For and on behalf of
BAE Systems
Interested Party Reference No.
20053944

COMMENTS ON DOCUMENTS SUBMITTED AT DEADLINE 3

Morgan and Morecambe Offshore Wind Farms Transmission Assets DCO Examination

August 2025

**Figure 1.8: Savick Bridge BHS, Lea Marsh BHS and Mason's Wood BHS close view**

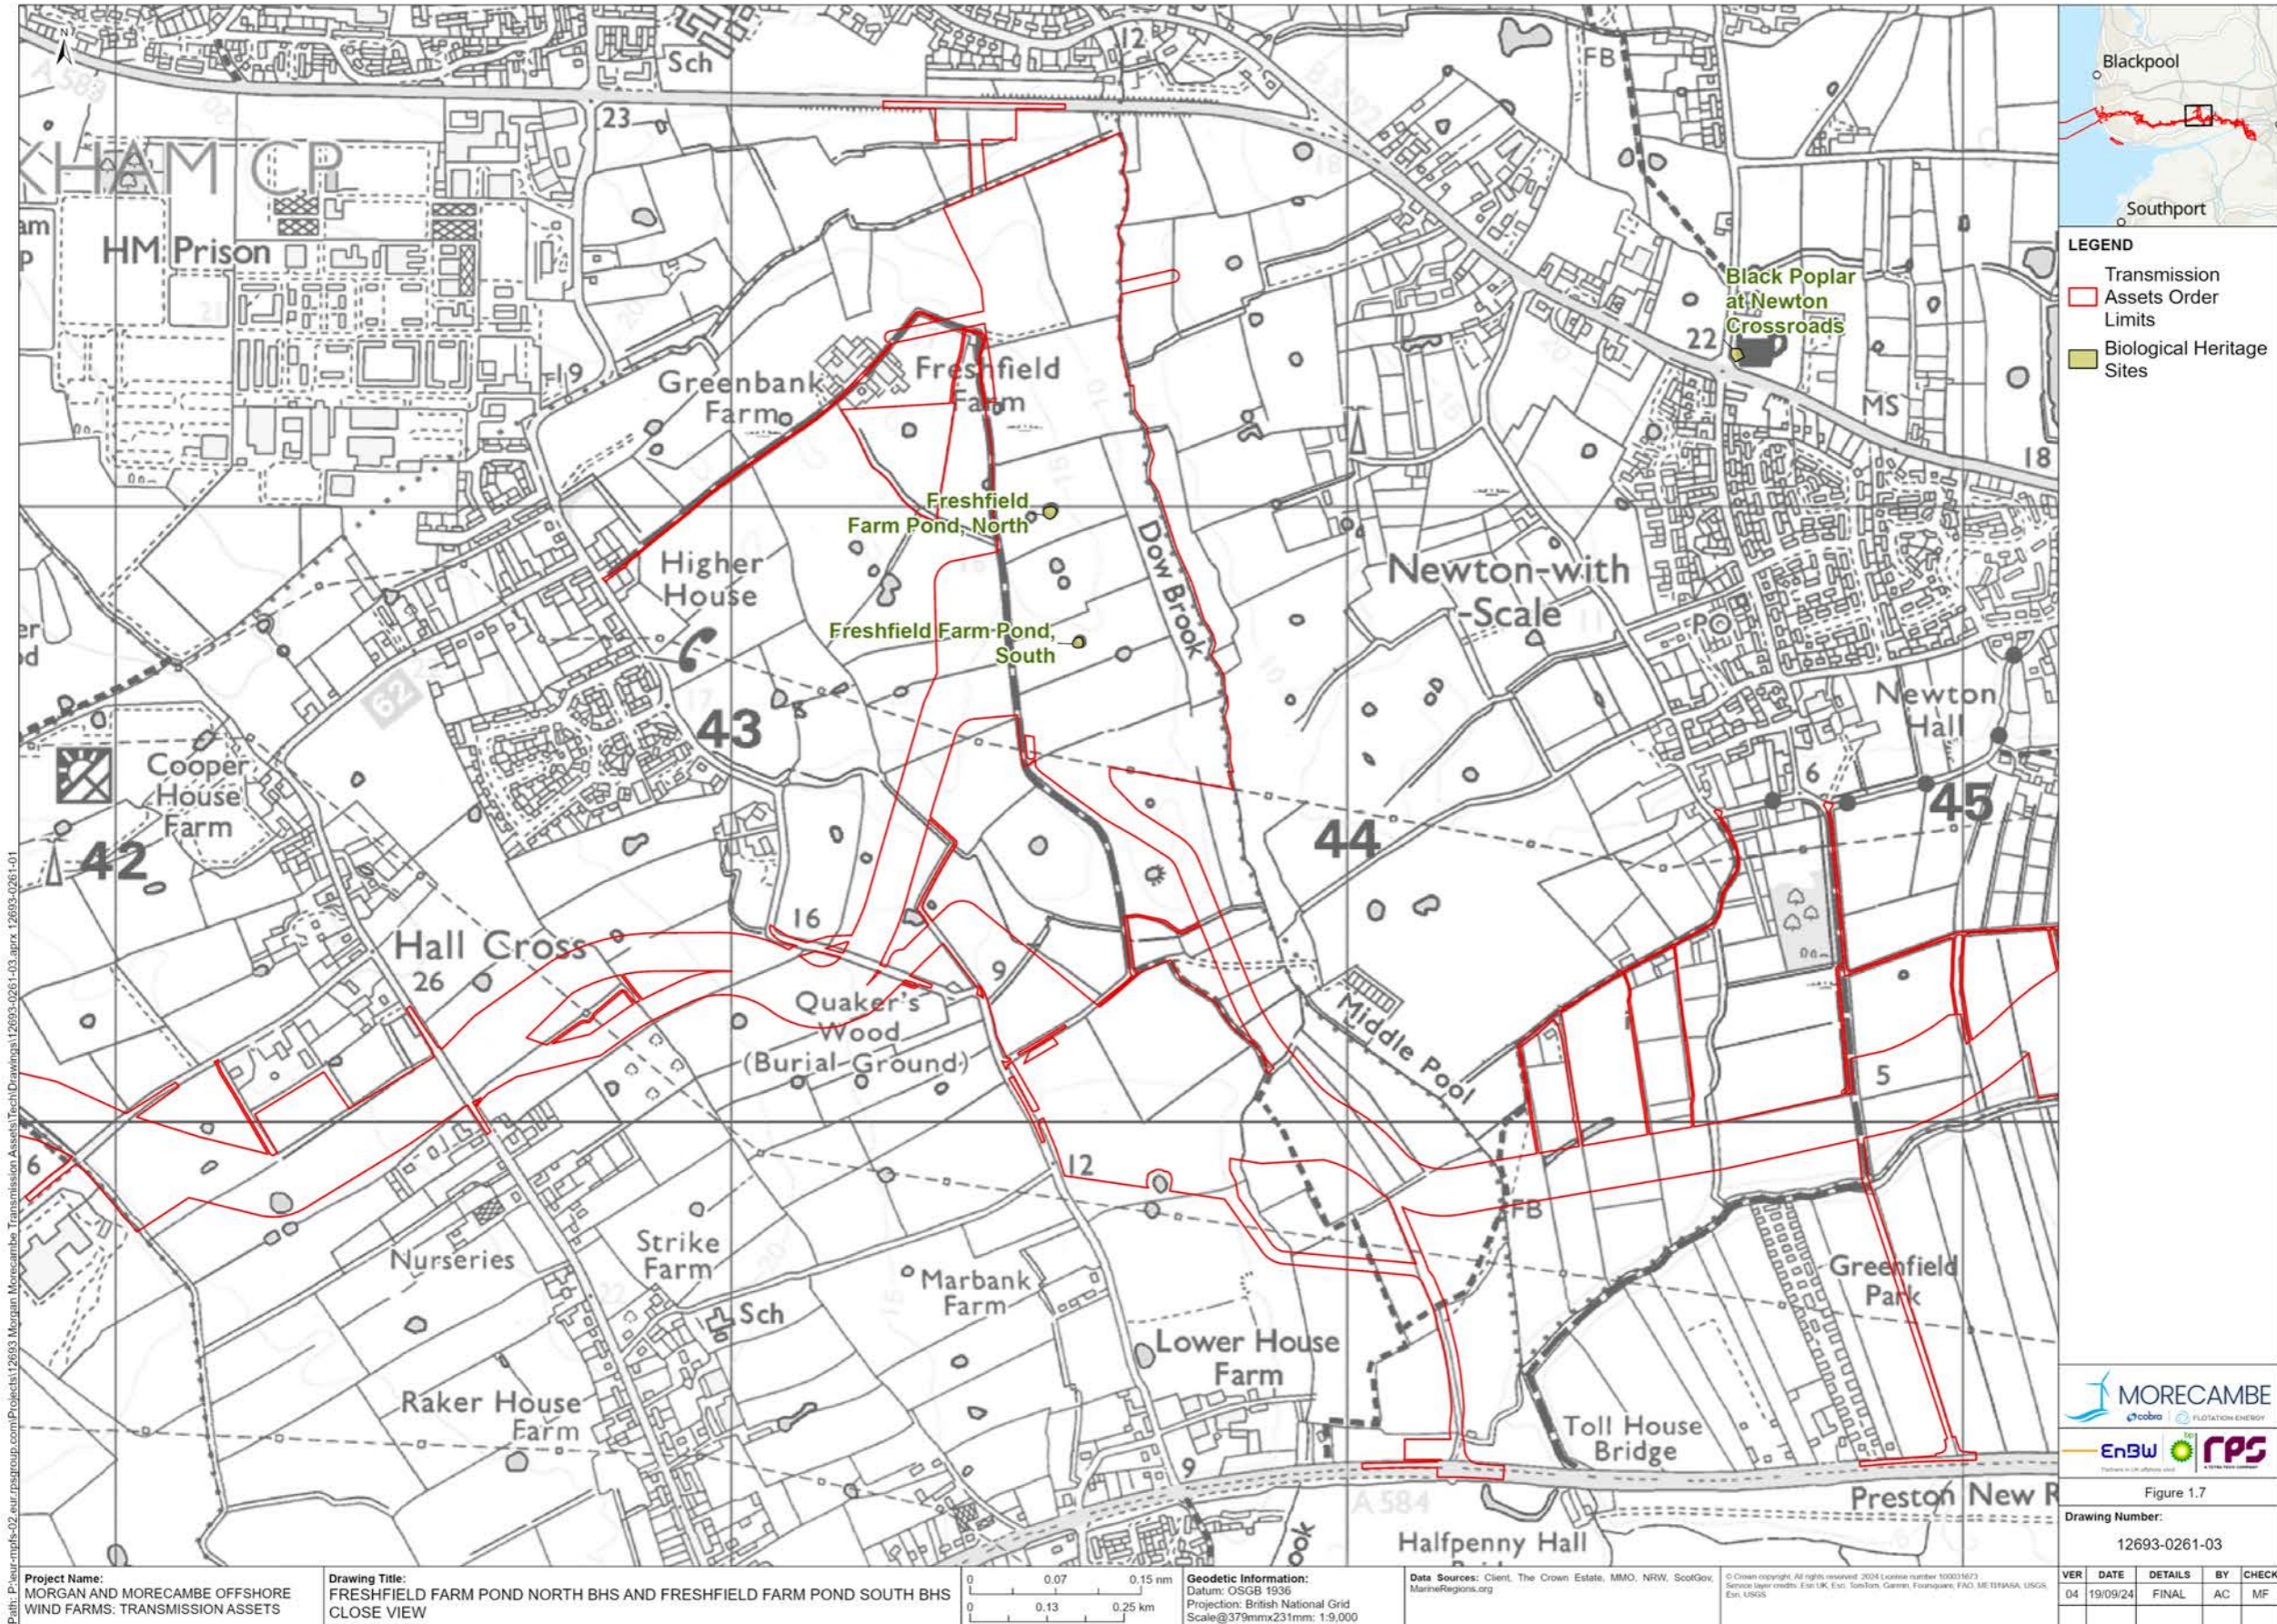
Paragraph Reference	Content (emphasis added)	BAE Systems' Comments
	management area. These species are set out in Table 1.1..... and have been agreed with Blackpool Airport. The Applicants await comment from BAE following a requested submitted on 29 th May 2025.	<p>that the species included in that document include those that BAE Systems currently monitor at Warton Aerodrome. BAE Systems would also expect the Applicants to consider the potential for the proposed development to attract any new bird species to the area that may pose a bird strike risk.</p> <p>BAE Systems has confirmed this statement in its Deadline 4 submission "<i>Response to ISH2 and ISH3 Action Points</i>" in response to ISH2 Action Point 11.</p>
Table 1.2	General comment on content of Table 1.2	Table 1.2 identifies potential habitat creation proposals / features that may constitute wildlife / bird attractants. BAE Systems understands that Table 1.2 will be updated following the wildlife attractant habitat risk assessment to contain more details of the habitat features proposed. Table 1.2 should also consider the potential for habitat features to indirectly attract birds. For example, otter holts are proposed at Lea Marsh Biological Heritage Site. Increases in otter

Paragraph Reference	Content (emphasis added)	BAE Systems' Comments
		<p>habitat could indirectly increase bird numbers as birds forage on fish carcasses left by otters. Currently, Table 1.2 states that no mitigation would be necessary at this site. This needs to be reconsidered.</p> <p>The Wildlife Habitat Management Plan and wildlife habitat attractant risk assessment also need to consider how the ecology / biodiversity sites, any additional landscaping, and earthworks in combination could affect bird numbers, concentrations, and movement patterns in the area.</p> <p>Table 1.2 identifies that BAE Systems would be consulted on the design of some of the ecological mitigation and biodiversity benefit sites, although not all of them. BAE Systems does have concerns over the bird attractant risk for all of the Ecological Mitigation Areas and Biodiversity Benefit Sites. Designs for all the sites will therefore need to be developed in consultation with BAE Systems and the MOD</p>
